WEST SUSSEX COUNTY COUNCIL CONSULTATION

TO:	Arun District Council FAO:Andrew Wood
FROM:	WSCC - Highways Authority
DATE:	21 November 2019
LOCATION:	Lanes End, West Walberton Lane, Walberton, West Sussex, BN18 0QS
SUBJECT:	WA/7/19/RES Approval of reserved matters following outline consent WA/26/18/OUT for layout & scale for 6 No. dwellings & 6 No. detached garages. New submitted plans received.
RECOMMENDATION:	Advice

PJ DEVELOPMENTS LTD 2 Square Chambers 23 High Street Emsworth PO10 7AQ Tel: 0843 289 3430 Email: enquiries@pjdevelopmentsltd.com	
PROJECT: FORMER LANES END	
SITE PLAN OUTLINE PLANNING APPLICATION	
DATE: JANUARY 2019	DWG. NO 19-001 PL02
SCALE @ A1: 1:200	
REV: C

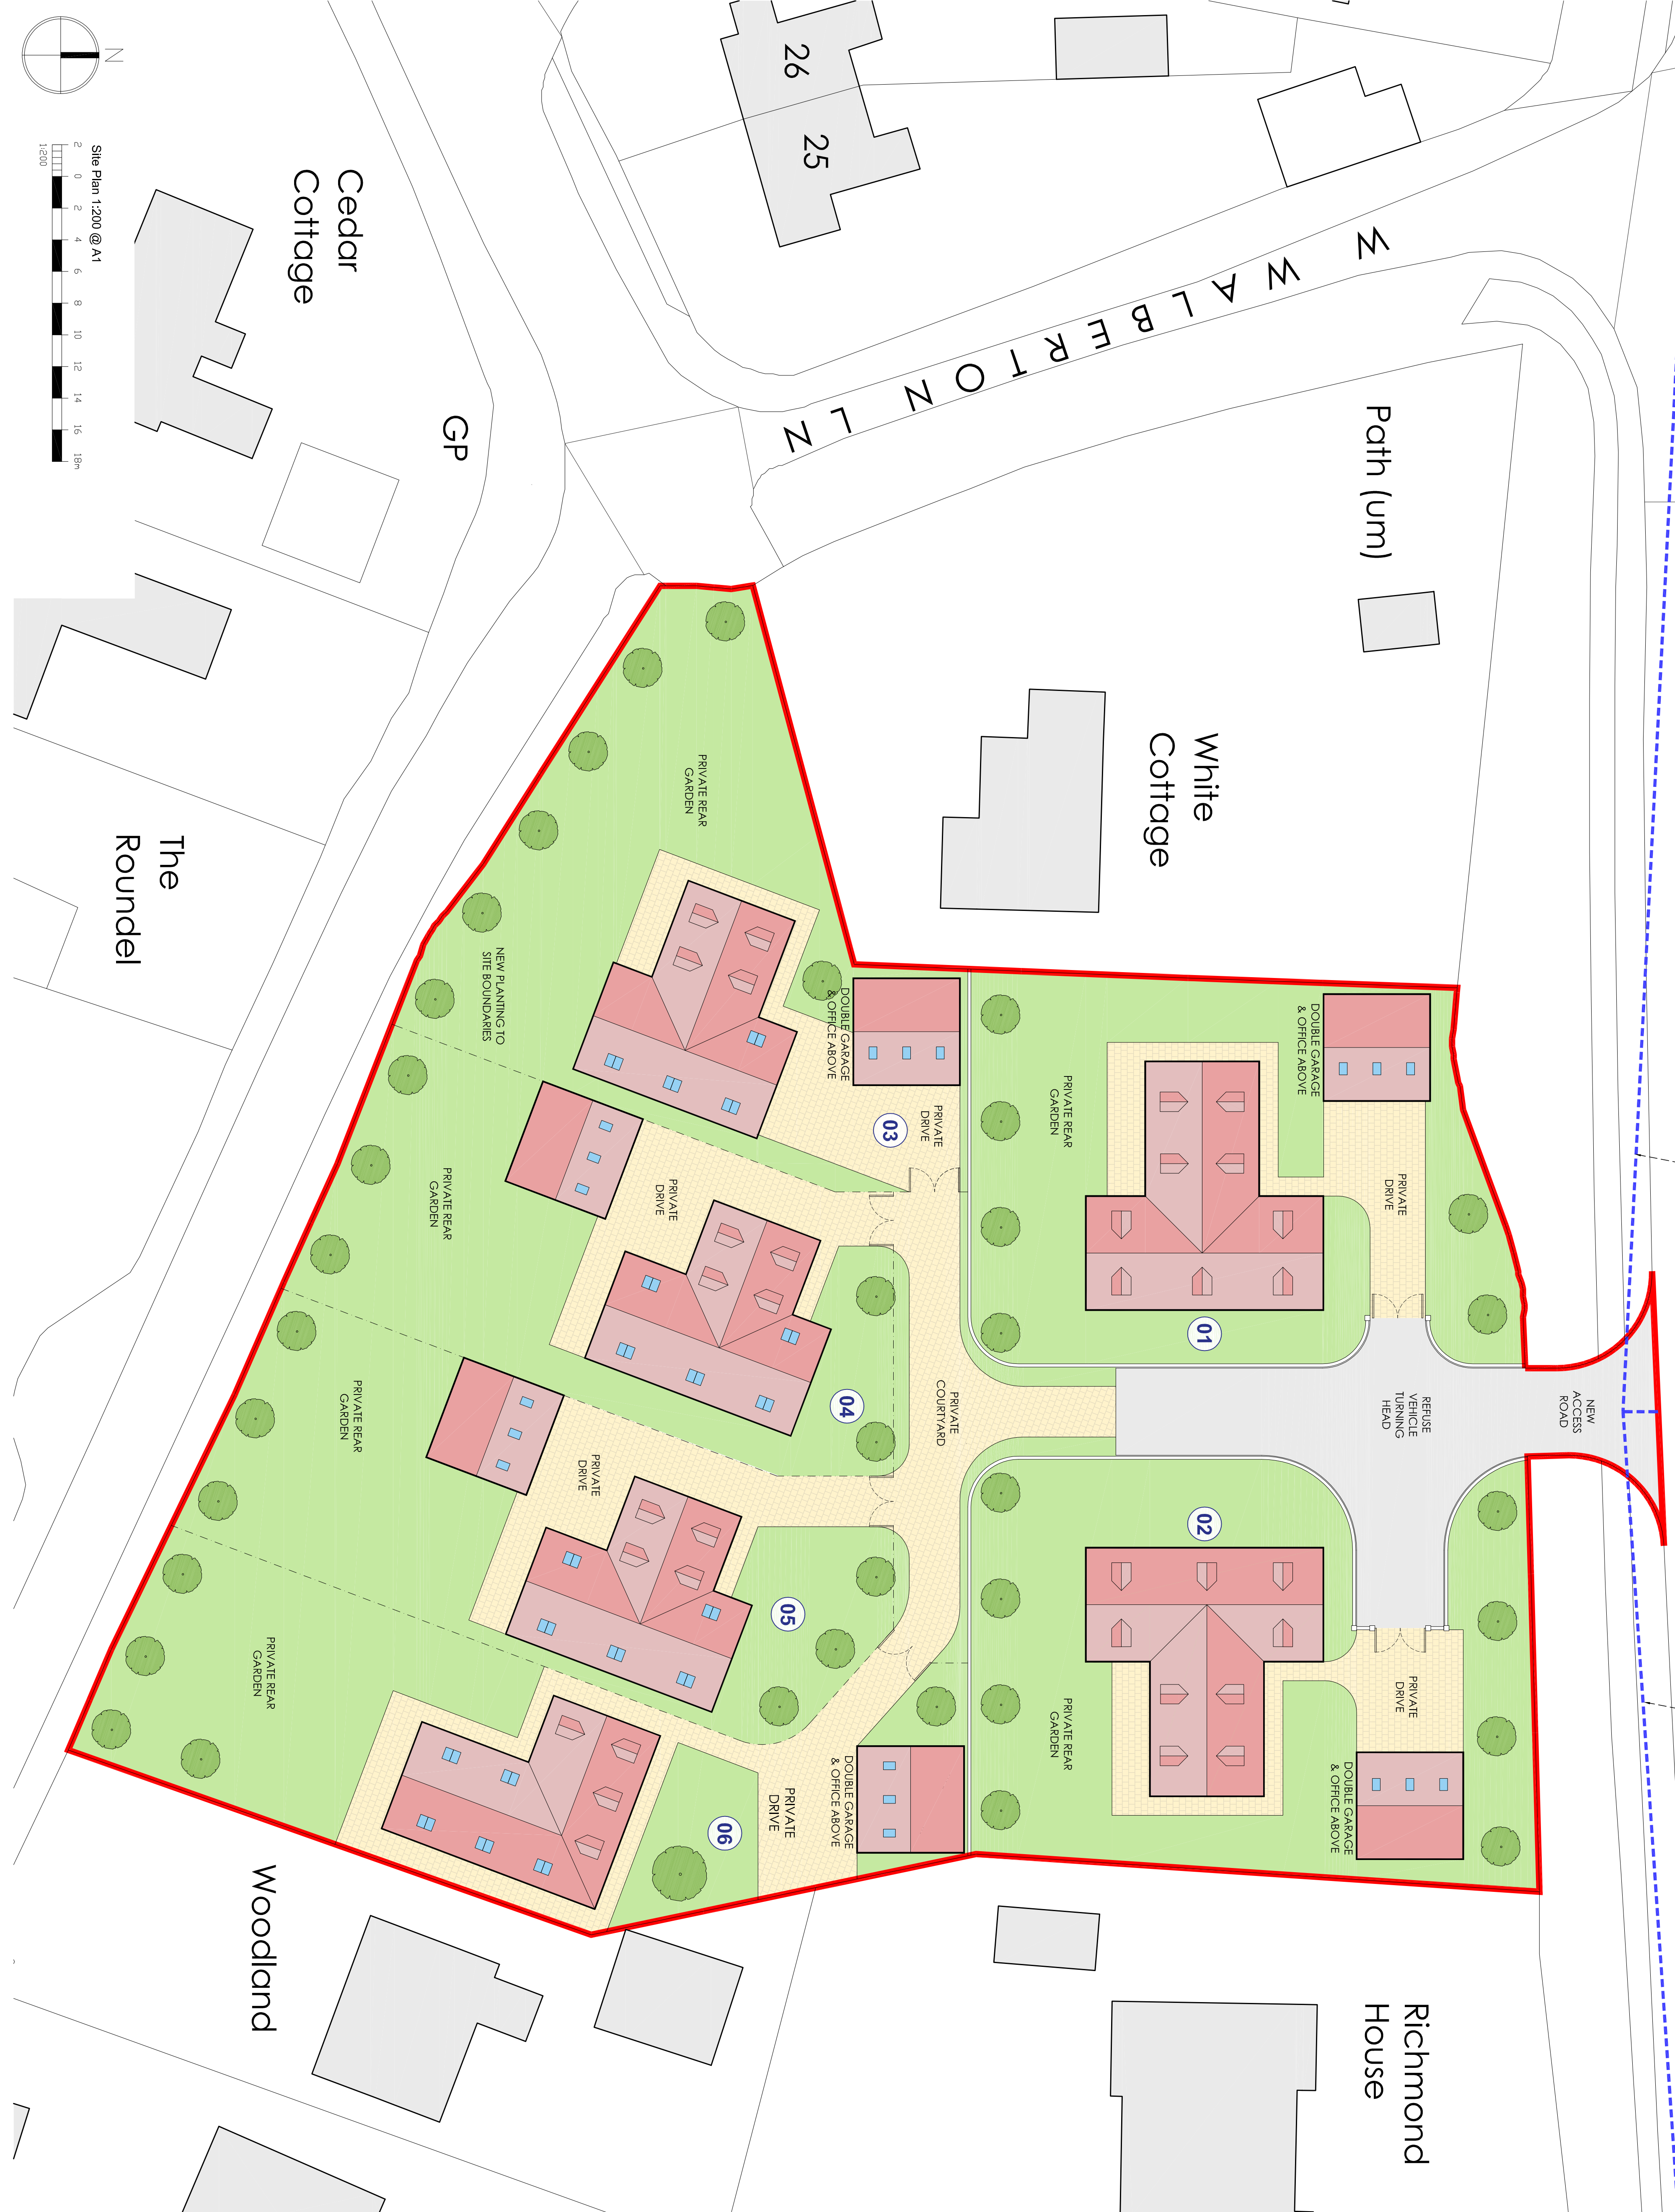
Drawing no. 19-001 SK111019 details a refuse vehicle turning head within the site, considering the site access and scale of development this would remain privately maintained. It would appear that the manoeuvre for a refuse vehicle would be restrictive and could require a multi-point manoeuvre. The LHA advise that Arun, as the local waste authority, are consulted on the proposed arrangements and whether collection from the roadside would be a preferred option. Considering level of forward visibility and existing properties on Arundel Road where bin collection is from the roadside, the LHA would not raise a highway safety concern if it were to be necessary to collect from roadside. However, waste authority should provide comments on preferred arrangements and ideally swept path tracking using relevant sized vehicle should be provided.

Floor plans and garage plans have now been provided. Each dwelling will be provided with a double garage at least 6m by 6m to count toward 2 x allocated spaces and provide bicycle storage. From an inspection of the plans there is also sufficient space within each plot for additional car parking and it is anticipated that cars can turn within the site and would not reverse to the public highway.
